City of Portland, Maine - Building or Use Permit Application
 389 Congress Street, 04101 Tel: (207) 874-8703, Fax: (207) 874-8716

| Permit No: 05-1323 | Issue Date: | CBL: 111 A010001 |

| Location of Construction: 425 FOREST AVE | Owner Name: FLETCHER IRENE E & WENDALL | Owner Address: 48 REVERE ST | Phone: |

| Past Use: Vacant Space / Convenience Store | Proposed Use: Pizza Restaurant / Tenant fit-up / | Permit Fee: \$537.00 | Cost of Work: \$48,335.00 | CEO District: 1 |

BUILDING RENOVATION
 PLAN SCALE 1/4" = 1'-0"

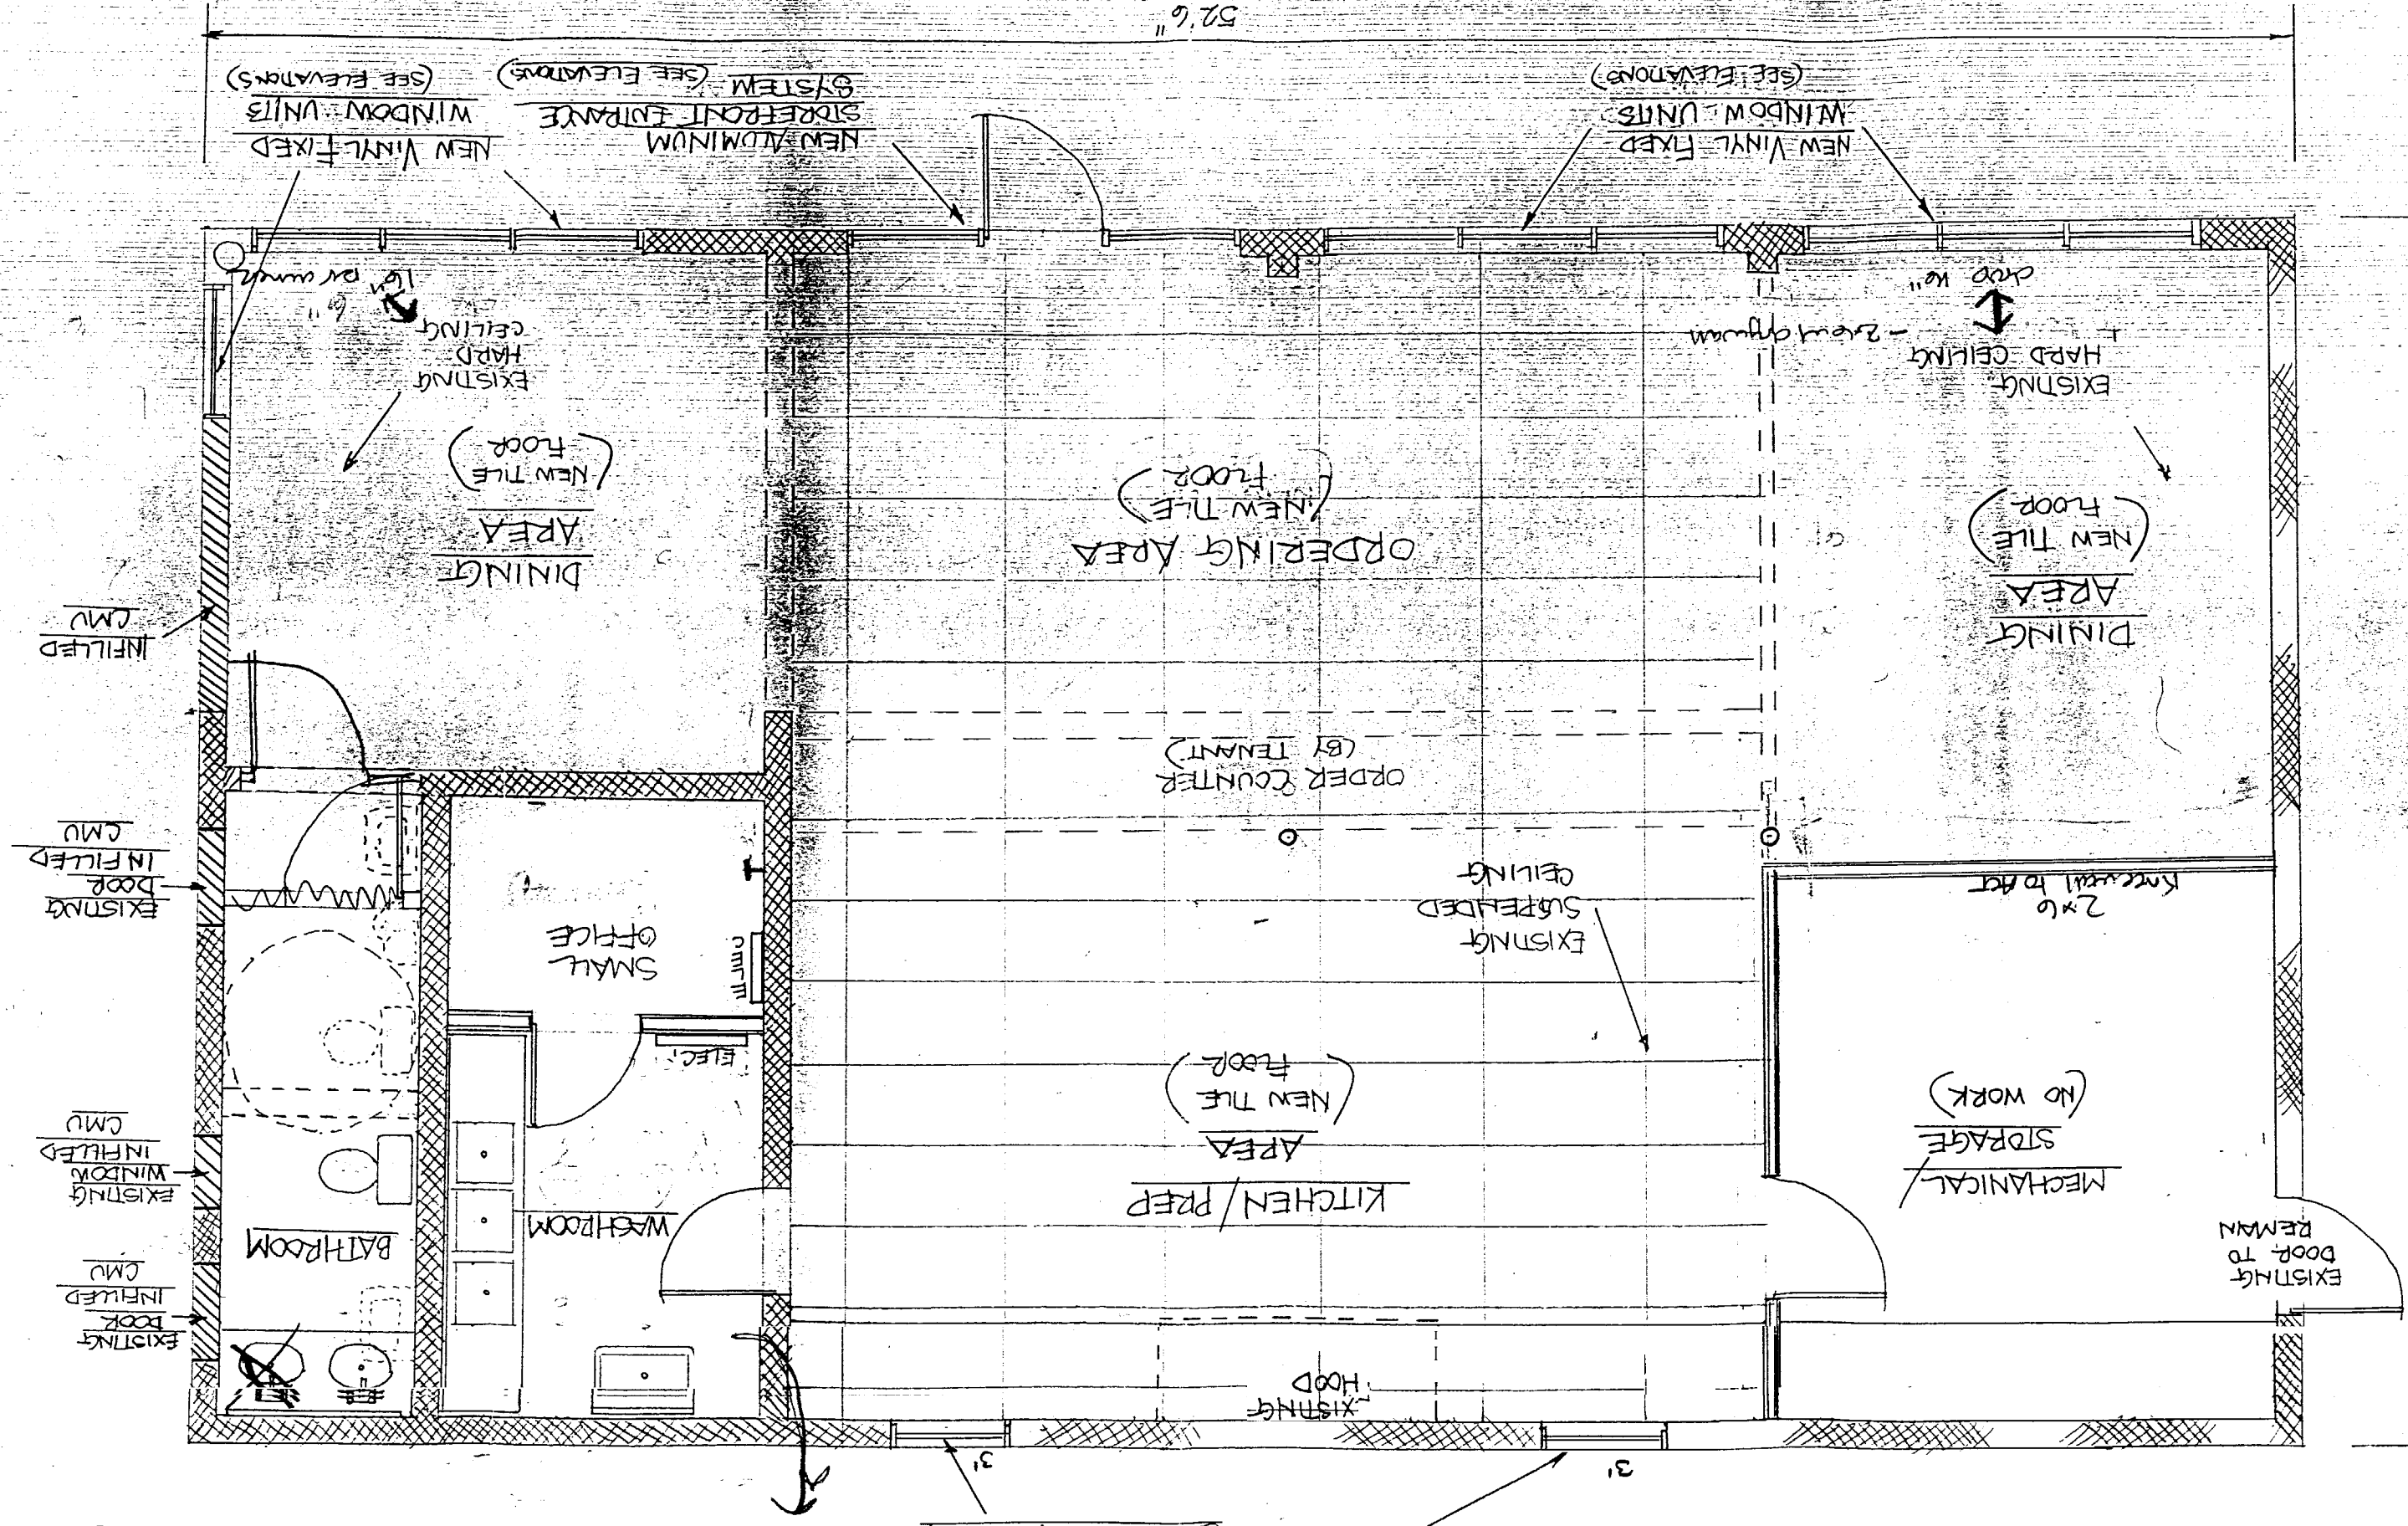
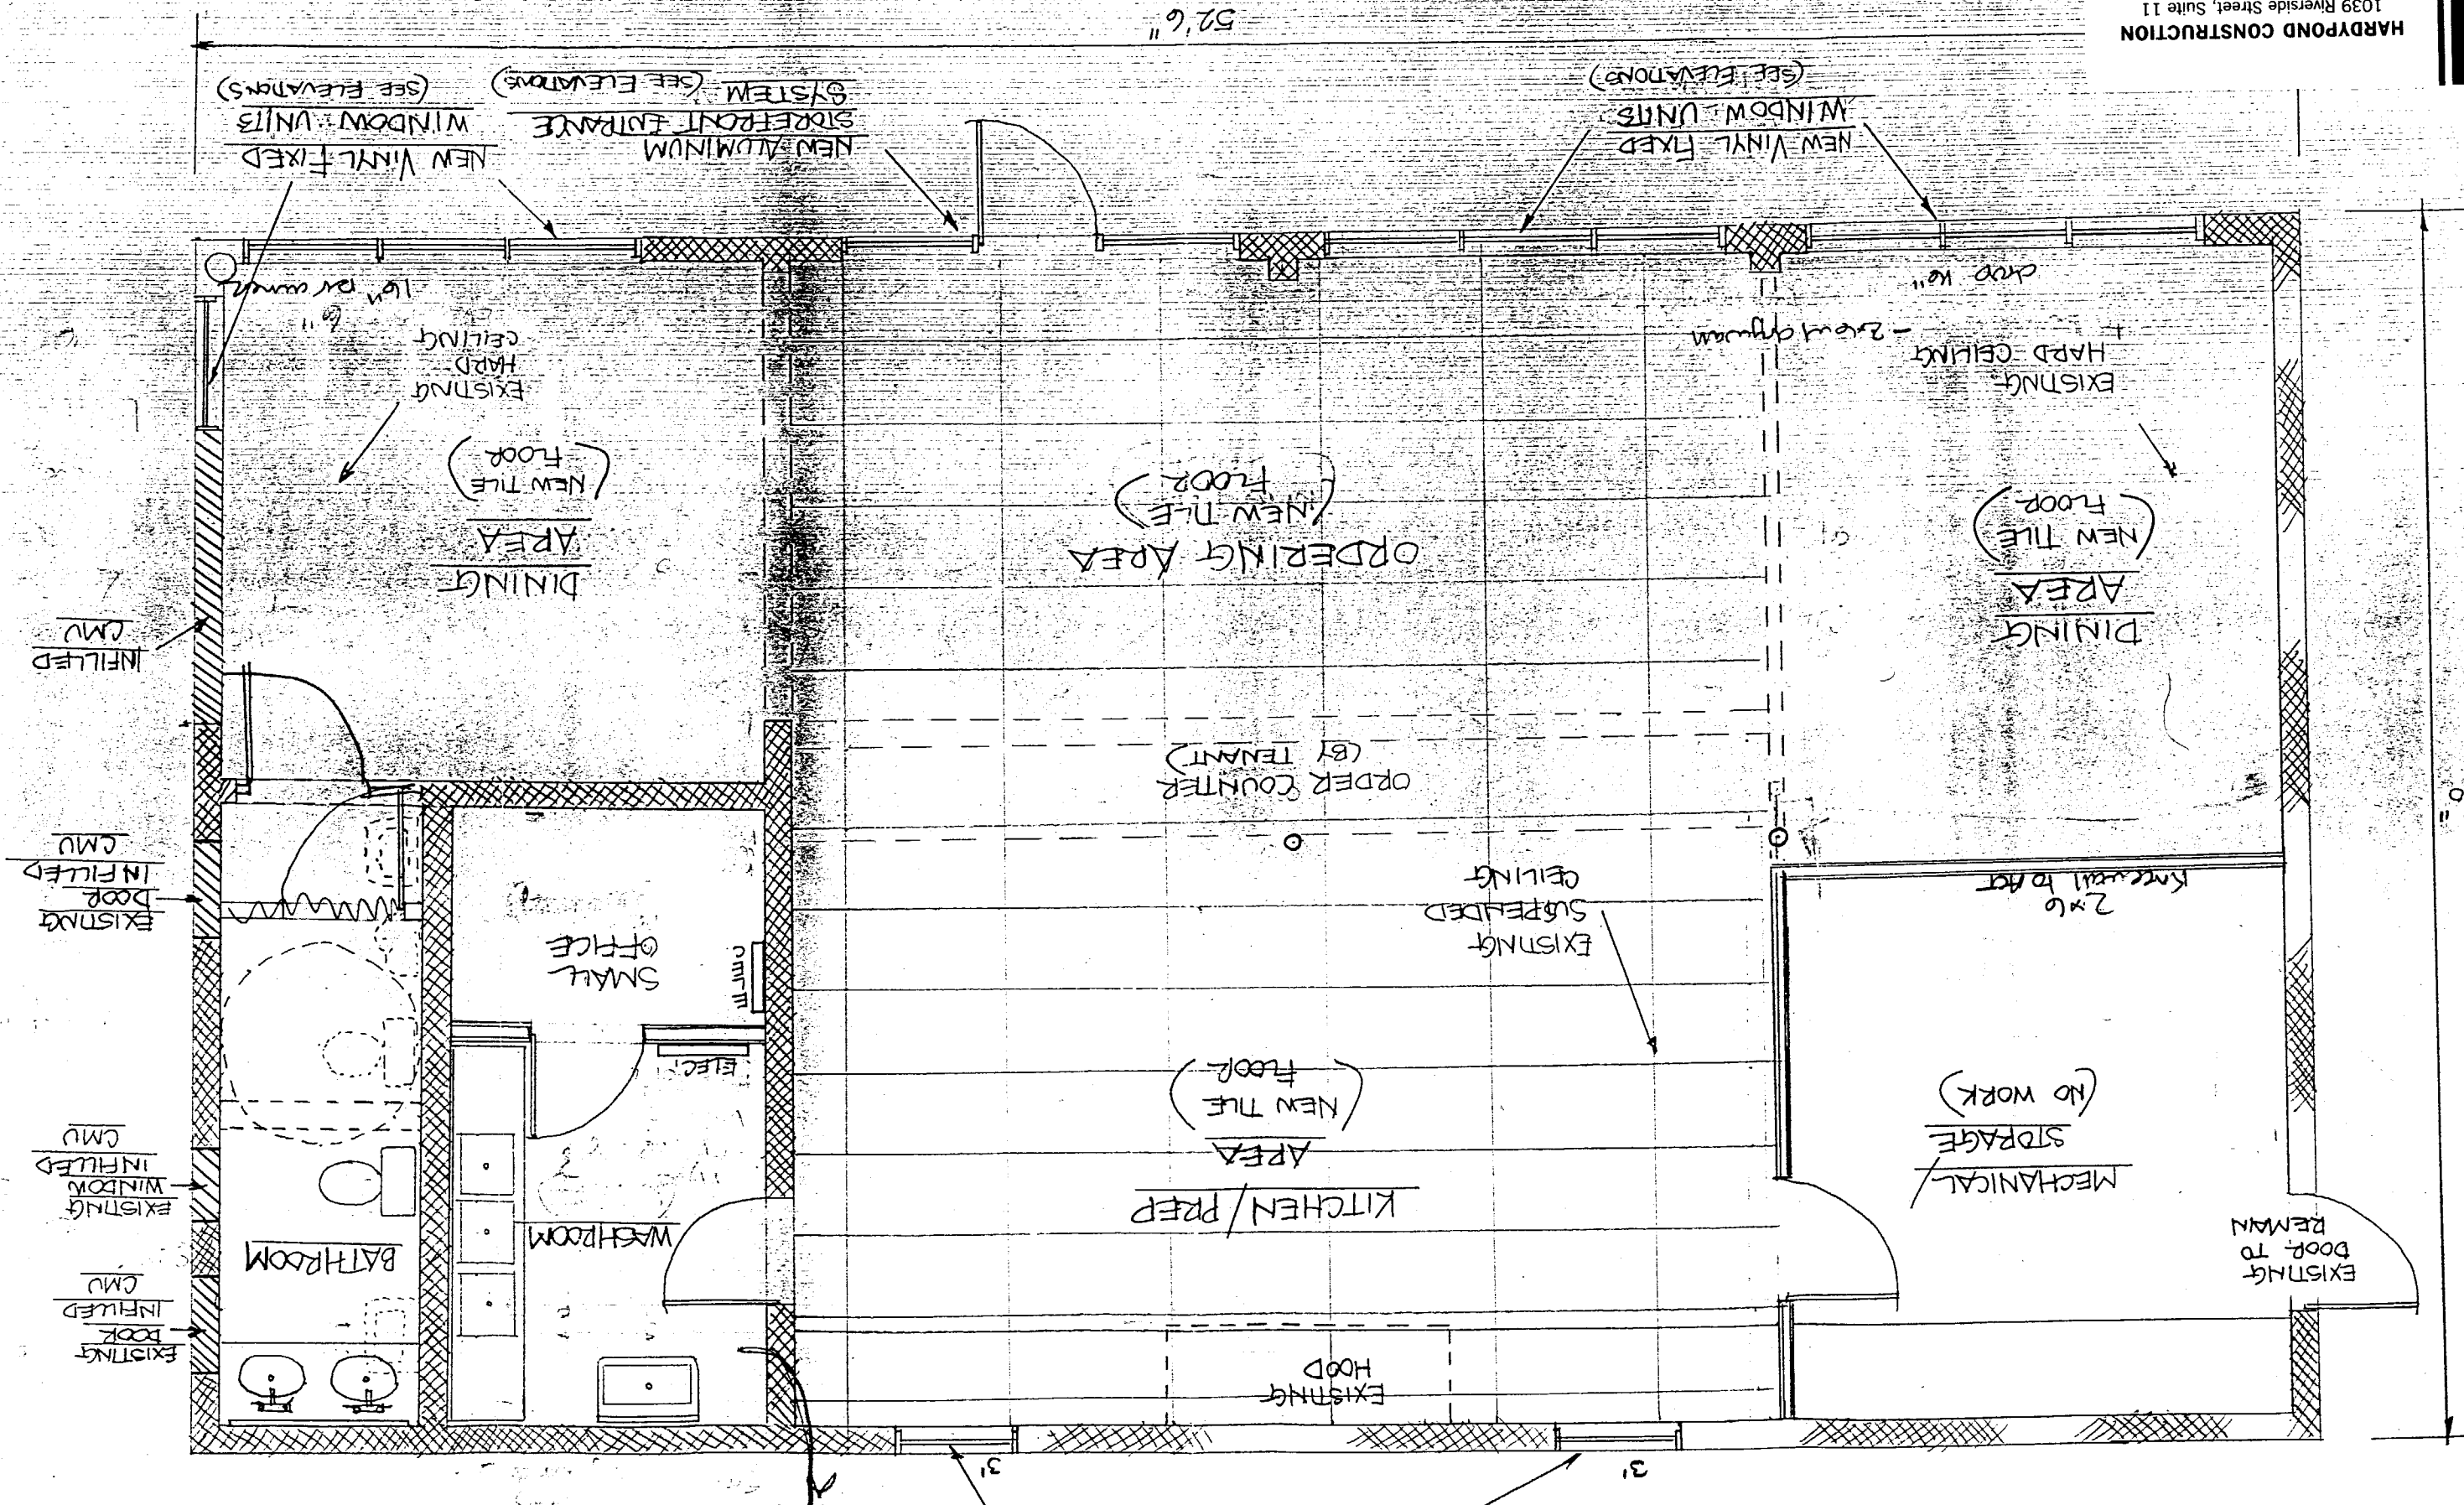
| 10/5/2005-mjn: Need seating plans, local exhaust info (or cooking equipment info) grease trap??? Spoke w/ GC and left two messages w/owner. |

| 10/5/2005-ldobson: Received floor plan and possible info on grease trap. Gave him the sheet for Hood System said he doesn't think he needed it gave it to him anyway said Hood system is existing. LJD put permit back in MJN Bin |
